KITTITAS COUNTY COMMUNITY DEVELOPMENT SERVICES

February 9, 2022

RE: Morazz Short Plat (SP-22-00001) - Determination of Incomplete Application

SHEET 1 OF 2

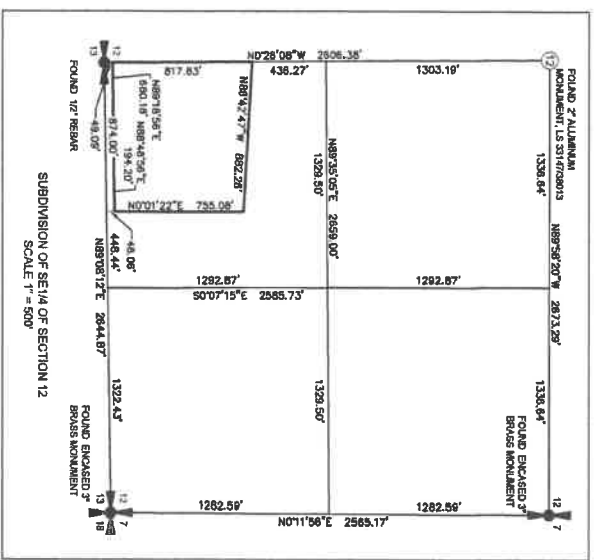
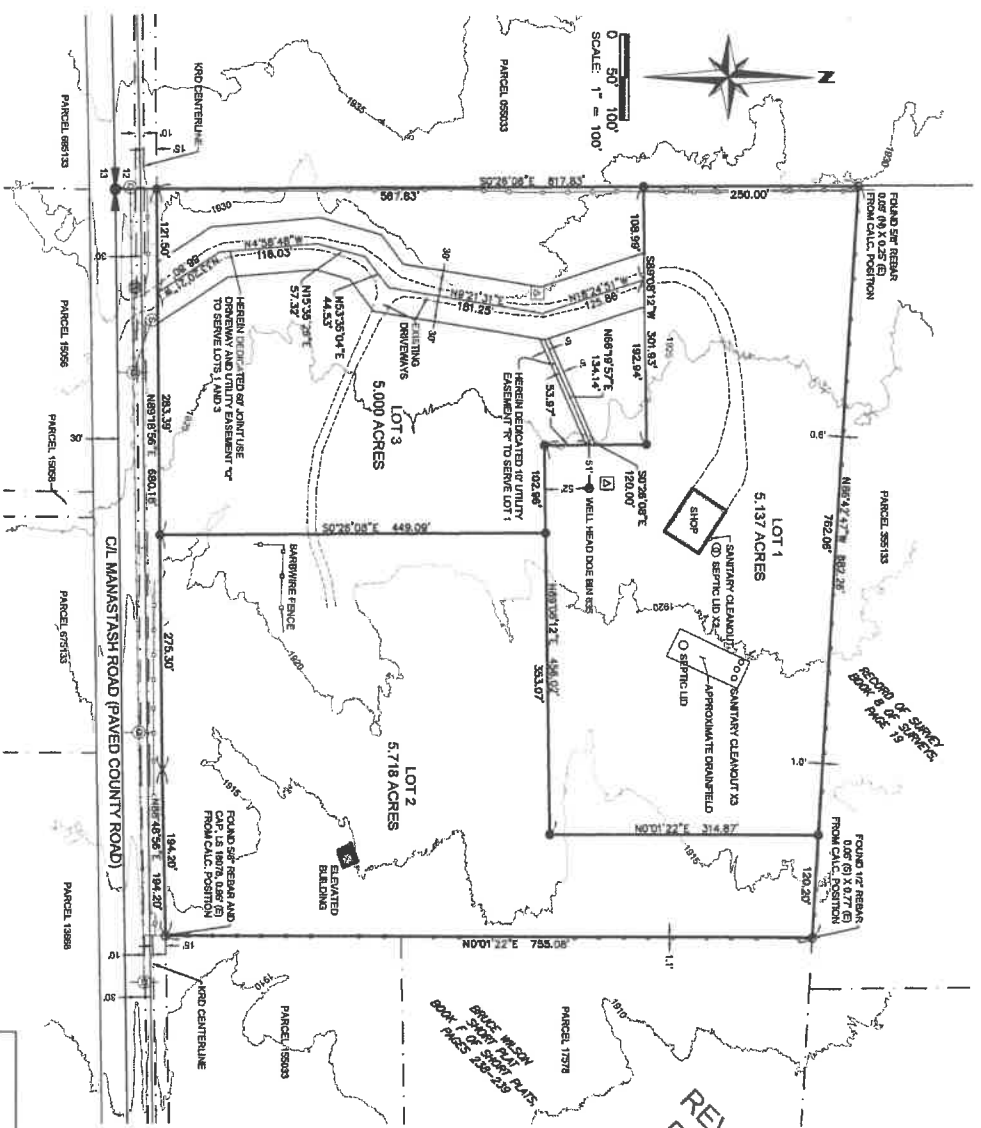
Thank you for applying to Kittitas County for a Short Plat regarding parcel number 335133. Community Development Services has reviewed your submitted materials and has determined that the application is not complete. This determination is based on our preliminary critical areas review and the identification of a Type F stream located on the property. Kittitas County's GIS data indicated that the stream runs adjacent to the irrigation ditch identified on the survey. The preliminary survey needs to include all critical areas in order to be deemed complete.
